Phone: 0300 123 6780  
Email: [developeras@lancashire.gov.uk](mailto:developeras@lancashire.gov.uk)  
Your ref: 3/2025/0752  
Our ref: 3/2025/0752/HDC/KW  
Date: 09 October 2025

**Location:** Fairfield Eastham Street Clitheroe BB7 2HY  
**Proposal:** Proposed demolition of existing garage, lobby and utility room to be replaced with single storey kitchen extension and store.  
**Grid Ref:** 374191 442328

The Local Highway Authority (LHA) are in receipt of an application for the proposed demolition of existing garage, lobby and utility room to be replaced with single storey kitchen extension and store at Fairfield, Eastham Street, Clitheroe.

1 0 PROPOSED GROUND FLOOR 1

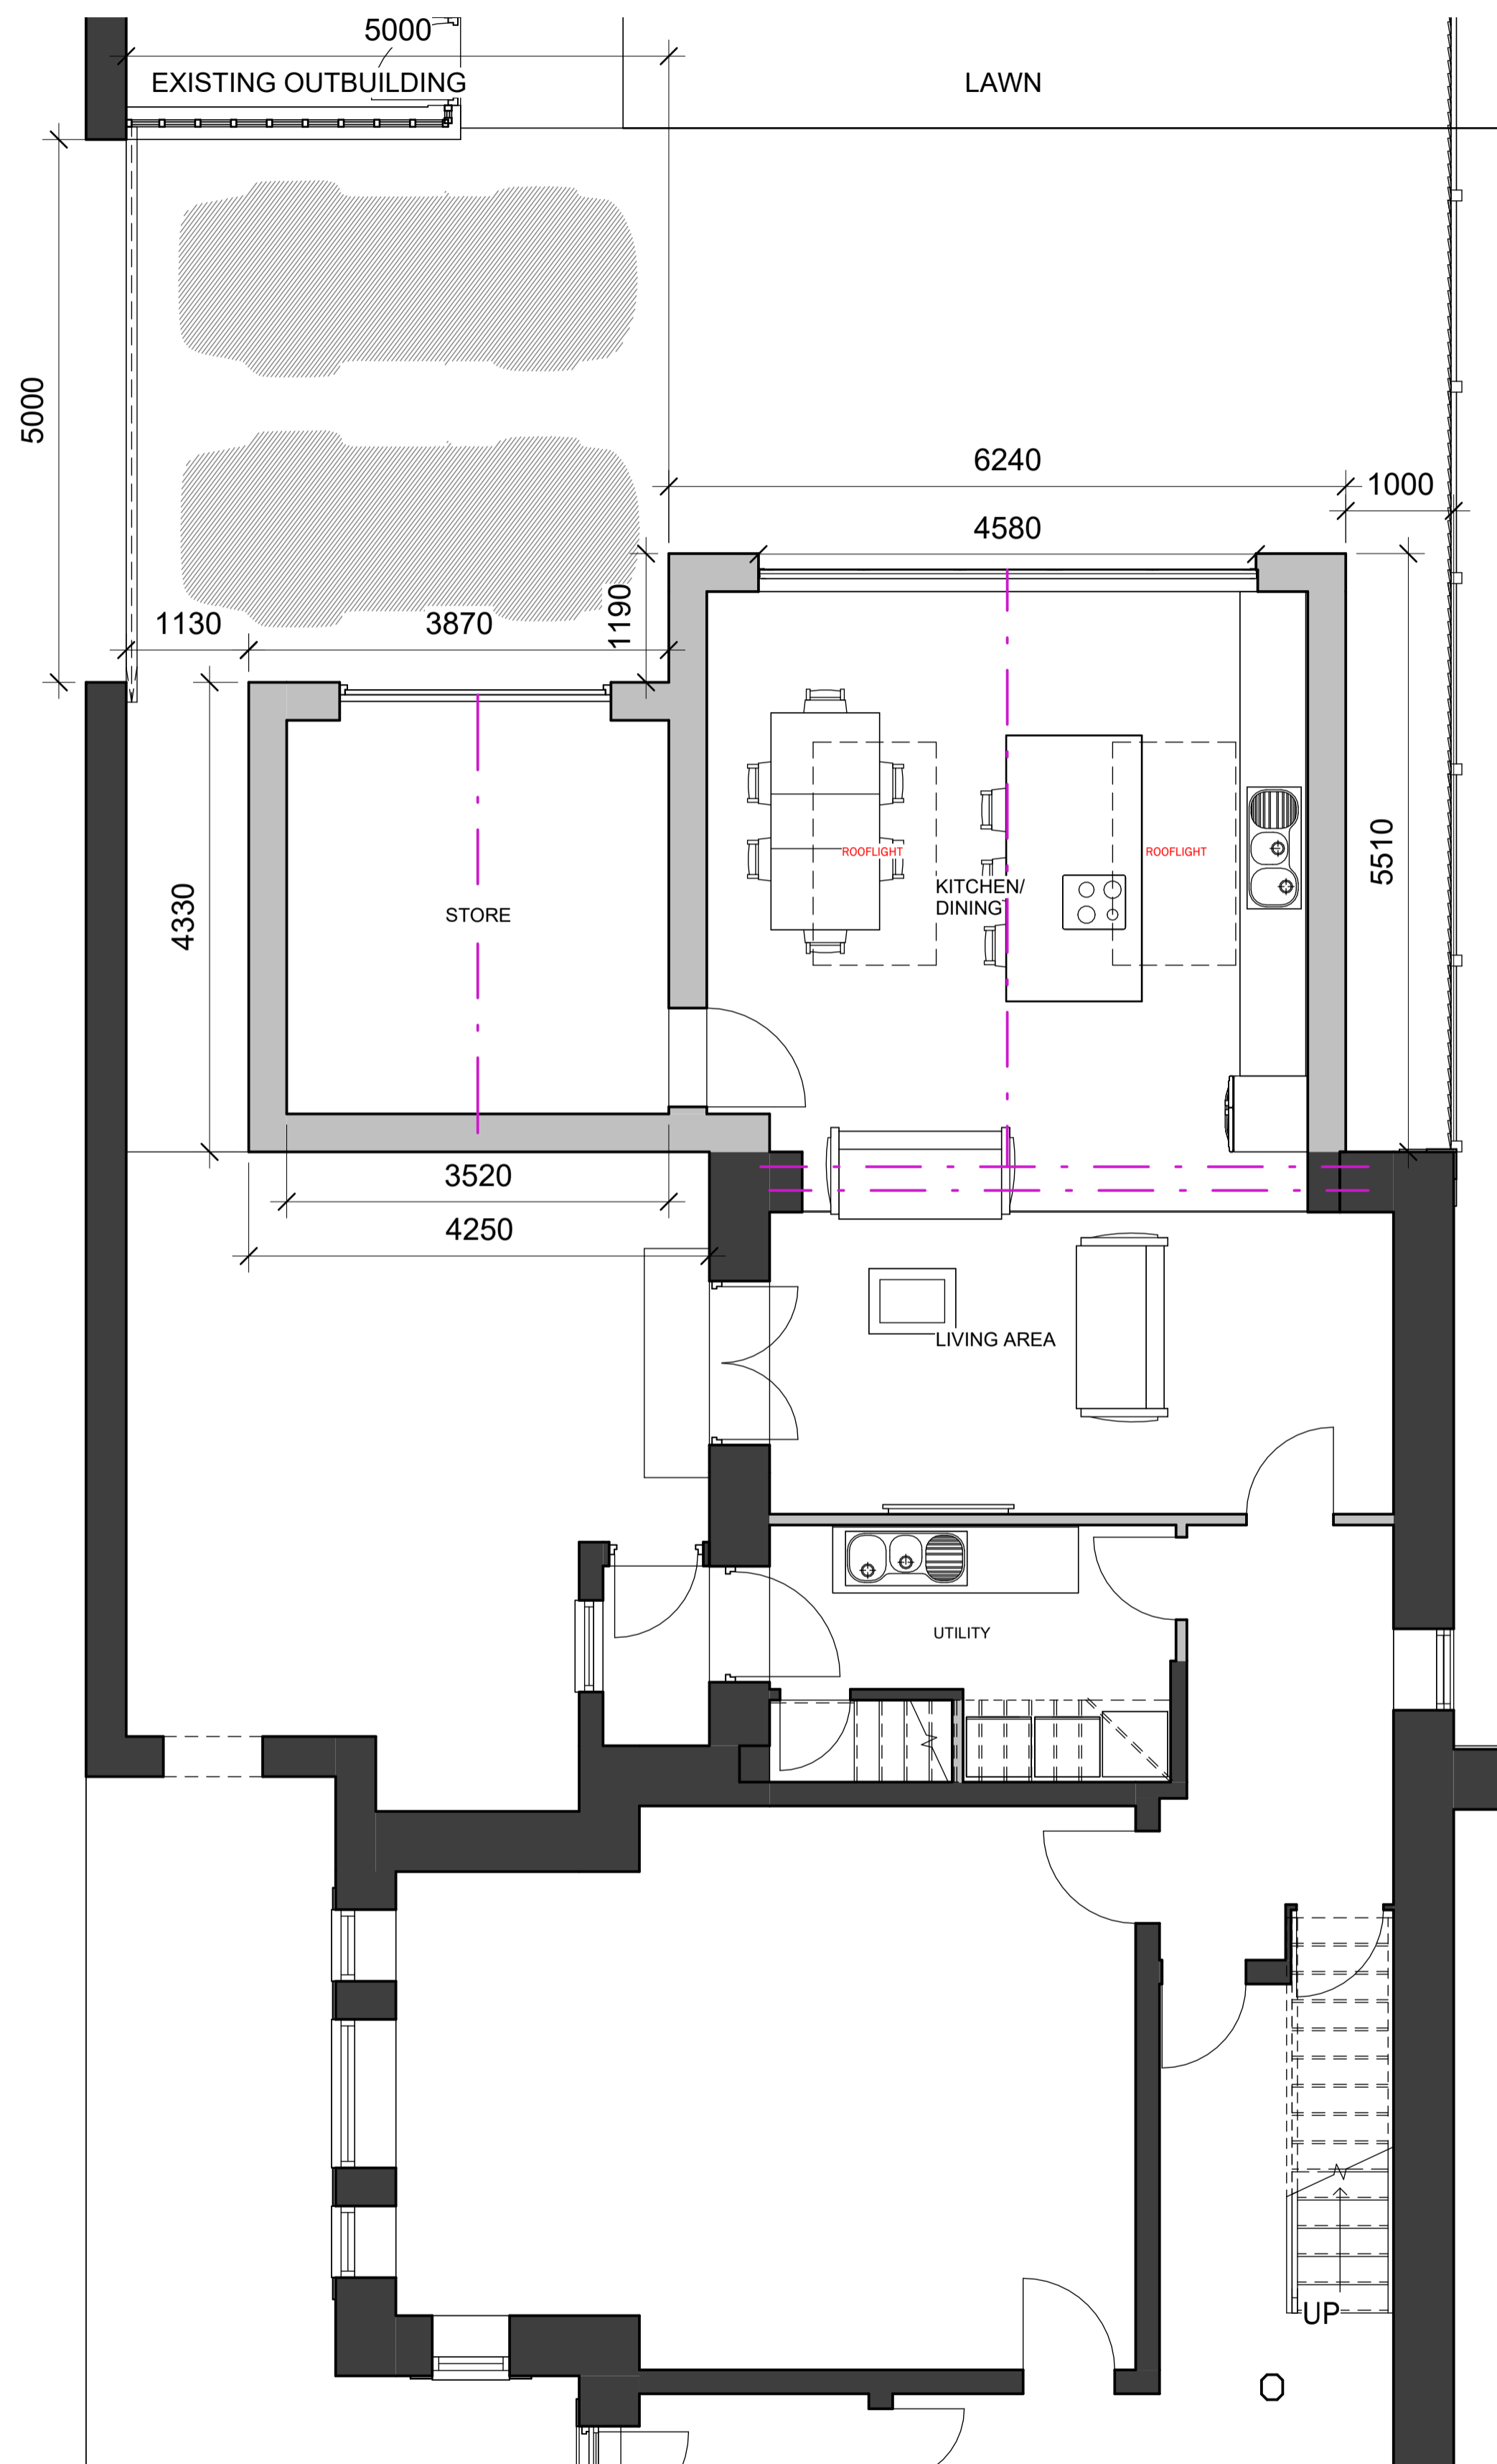
The LHA are aware that the proposal will result in the widening of the existing vehicle access to 5m wide. The accessed is on Eastham Street, which is an unclassified road subject to a 20mph speed limit. This is acceptable to Lancashire County Council's Highways, the extended vehicle crossing within the adopted highway will need to be constructed under a section 171 agreement of the Highways Act 1980.

The proposal includes the removal of an existing garage, replacing it with a store. The recommended minimum internal dimensions for a single garage size is 6m in length and 3m wide. The recommended distance of 6m is based on the length of a large family car (Ford Mondeo Estate 4.58m long), clearance at the rear of the car (200mm), overhang of the garage door (600mm) and room to stand in front of the car and open/close the garage door (600mm). As the existing garage does not meet the current internal recommended measurements, it is unlikely to provide off-street parking provisions currently due to its restricted length. As such, the LHA has no objections.

1. Before the widened parking area is used for vehicular purposes, it shall be appropriately paved in tarmacadam, concrete, block paviments, or other hard material to be approved by the Local Planning Authority.  
**Reason:** To prevent loose surface material from being carried on to the public highway thus causing a potential source of danger to road users.
2. All gates and associated mechanisms to be located outside the adopted highway and the gates to have physical restraints to prevent the gates from opening onto the adopted highway.  
**Reason:** to ensure the adopted highway is not obstructed or becomes hazardous to other road users, in the interests of highway safety.
